**RE: 98<sup>th</sup> & Sage Storage  
Conceptual Grading and Drainage Plan  
Engineer's Stamp Date: 09/07/23  
Hydrology File: M09D012B**

Based upon the information provided in your submittal received 09/08/2023, the Conceptual Grading and Drainage Plan **is not** approved for action by the Development Facilitation Team (DFT) on Site Plan for Building Permit. The following comments need to be addressed for approval of the above referenced project:

Response: Changed scale on GR-1.
4. Please change the Title of the sheet to "Conceptual Grading and Drainage Plan."
Response: See updated GR-1 plan.
5. Please add the note, "Not for Construction."

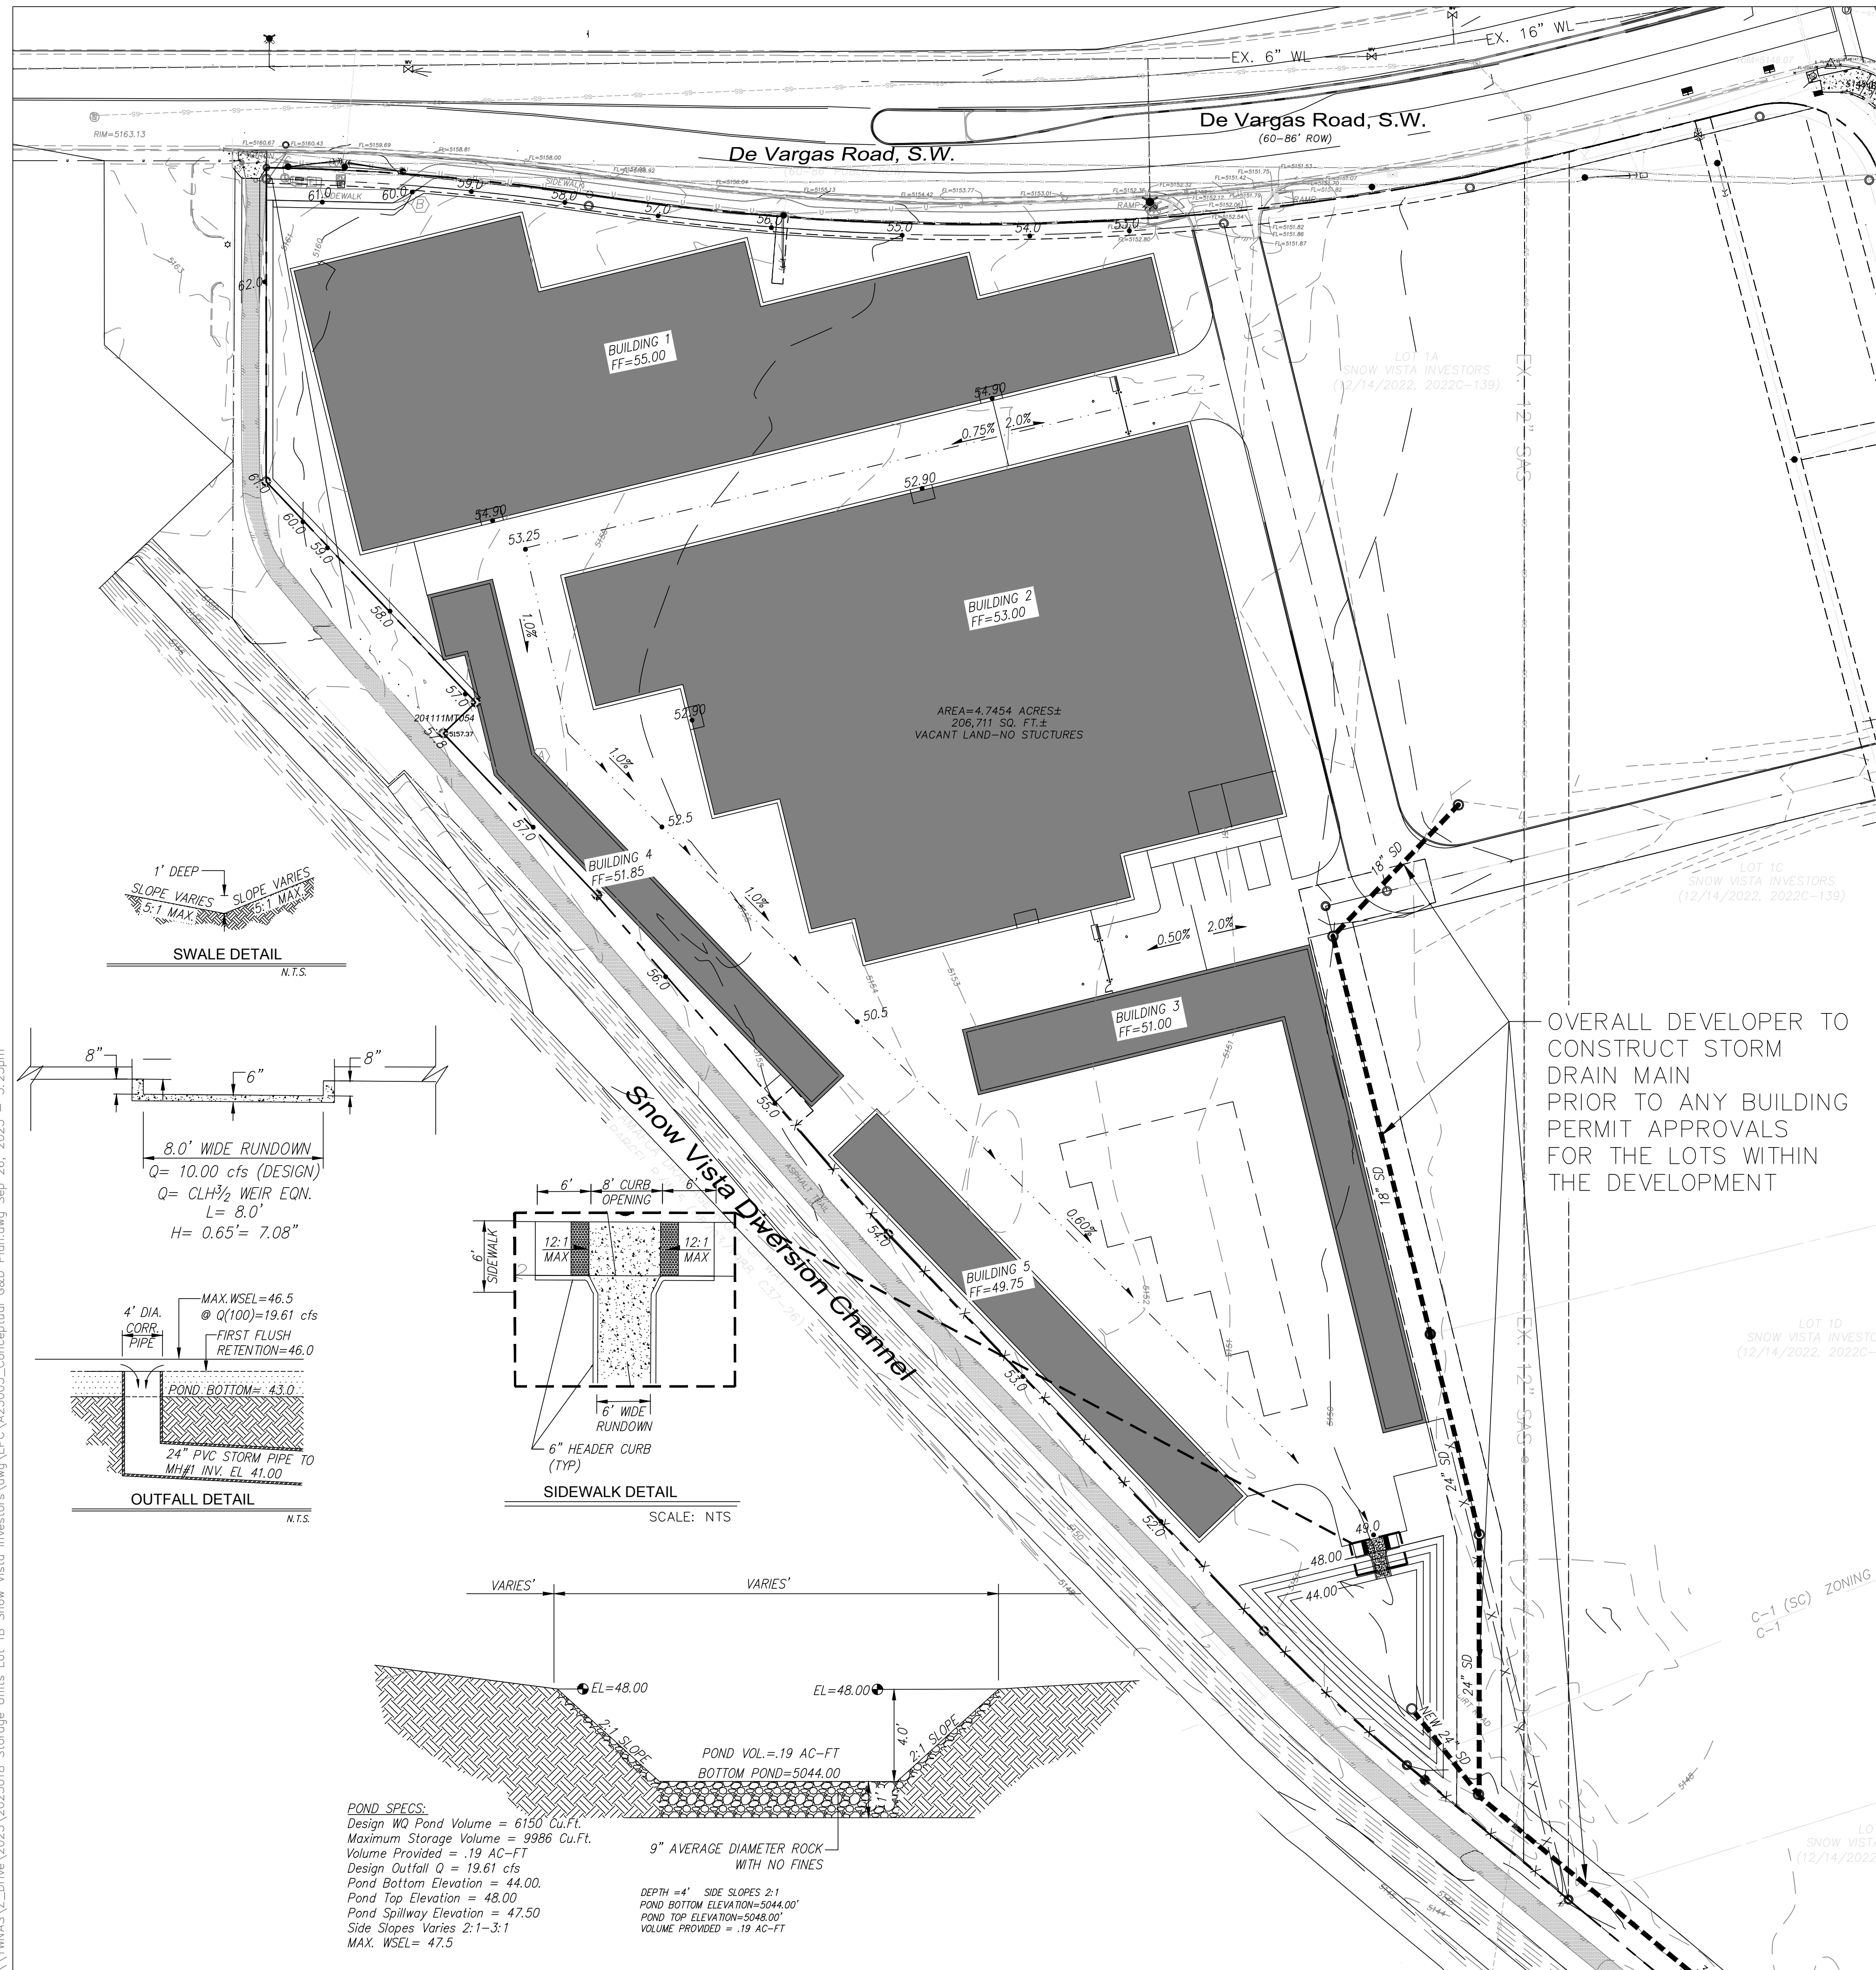
1. Please remove all the stormwater quality ponds around Building 1. All of these are on the High side of the development and will not capture any stormwater. Please make sure that the southeast pond is

2. Please show the storm pipe the was approved for the overall development on July 20, 2023. Please label as "Overall Developer to construct prior to any further Building Permit approvals for the lots within the development."

3. Please either consolidate the drainage calculations and the details to GR-2 and rename to GR-1 or change the scale on GR-1 to 1"=40'.
4. Please change the Title of the sheet to "Conceptual Grading and Drainage Plan".
5. Please add the note, "Not for Construction".
